Your ref:
Our ref: 24/00624/F
Please ask for: Charlie Collier
Direct dial:
E-mail: borough.planning@west-norfolk.gov.uk

10 April 2024

Details: **To renovate and extend the present garage to form a living area and to add an upper floor extension to form a new master bedroom and en-suite at 19 Avon Road South Wootton King's Lynn Norfolk PE30 3LS**

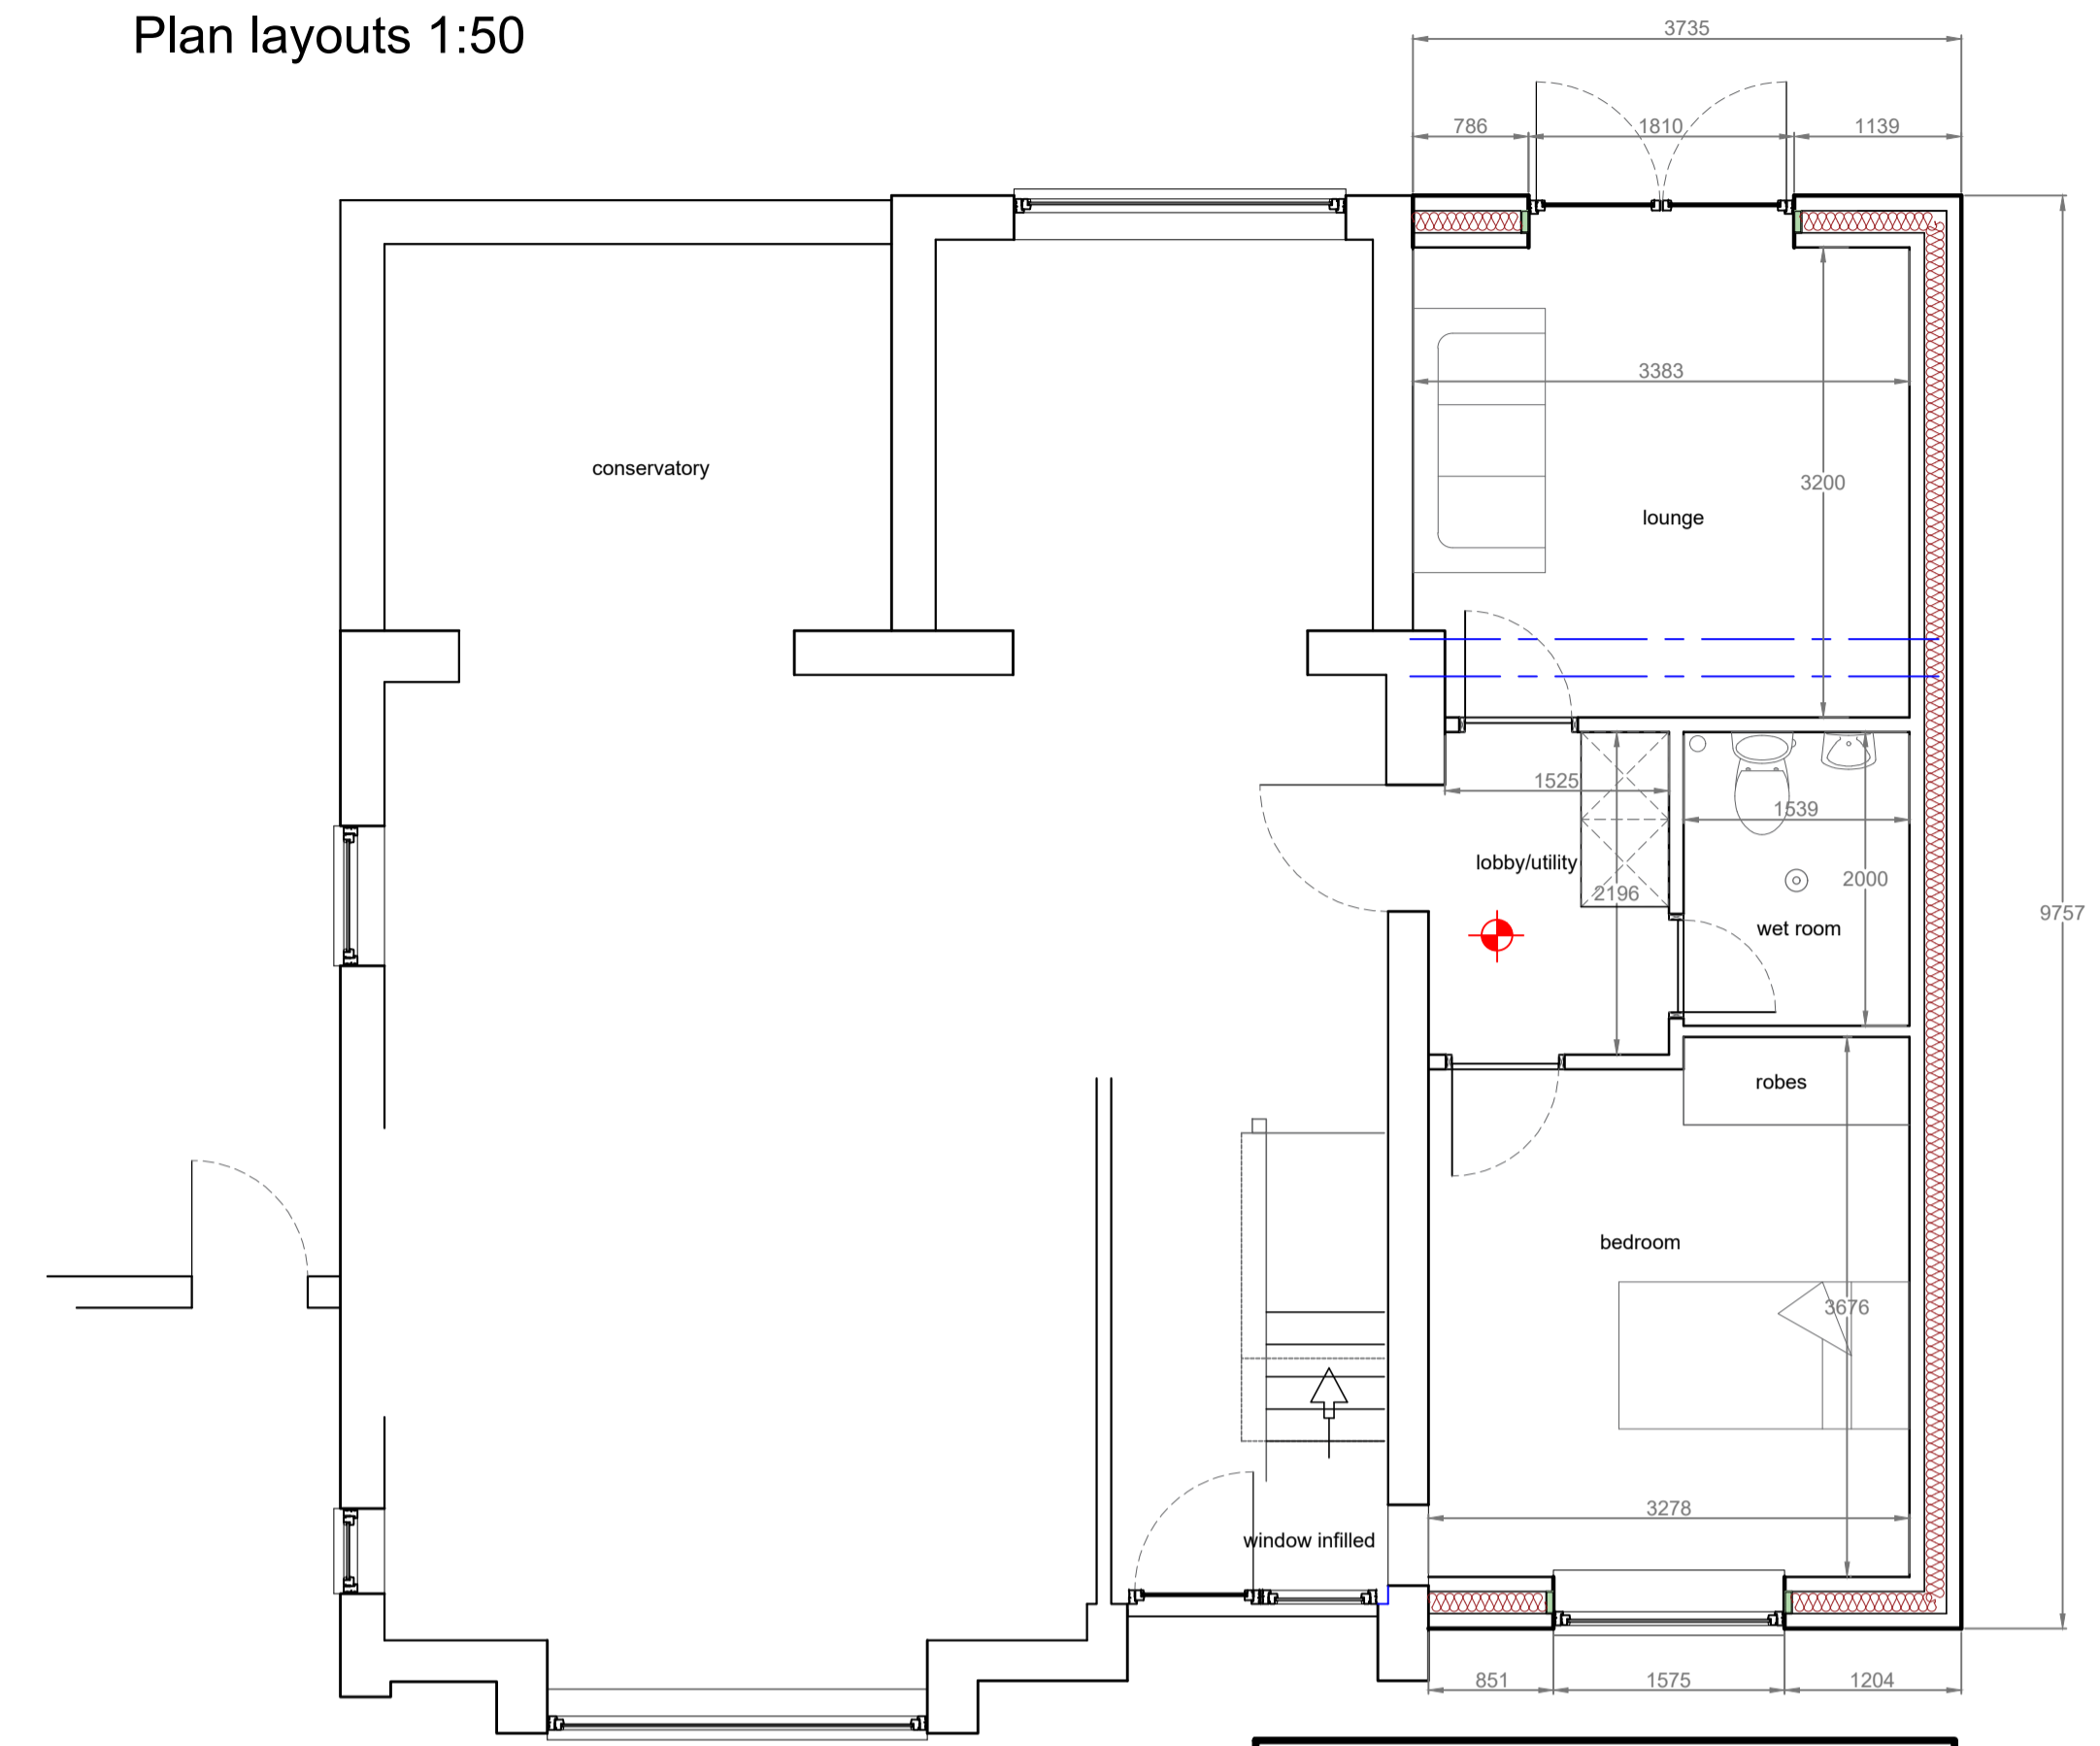
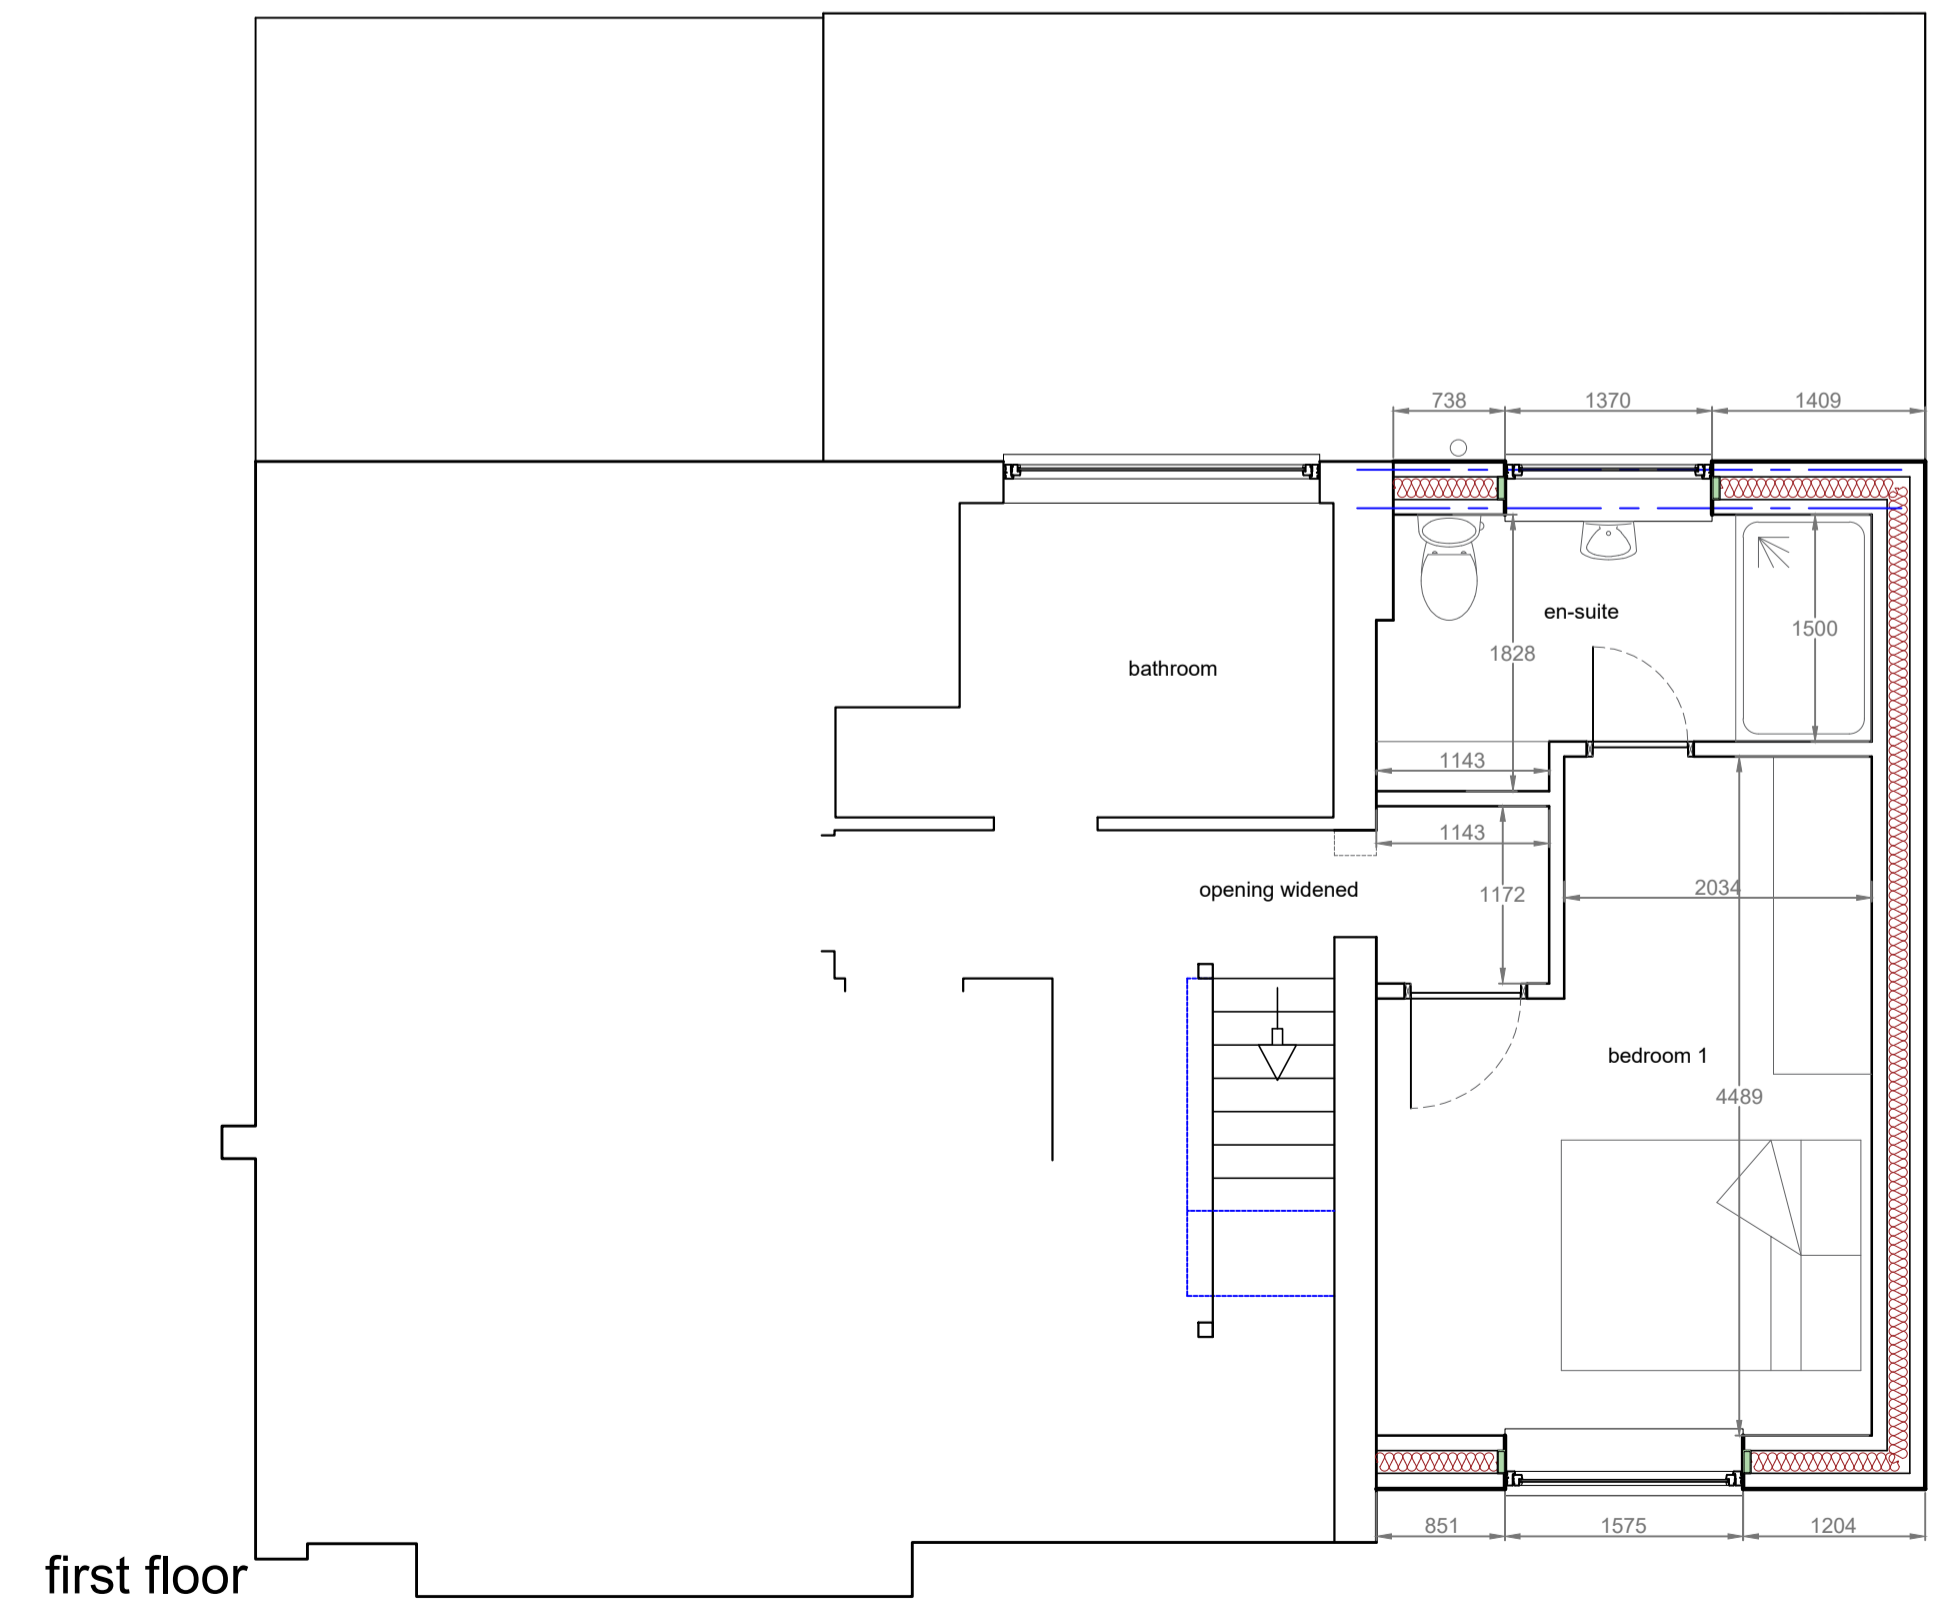
1. Please amend proposed plan to include annotations on elevations.
2. Please amend both proposed and existing floorplans to match elevations.
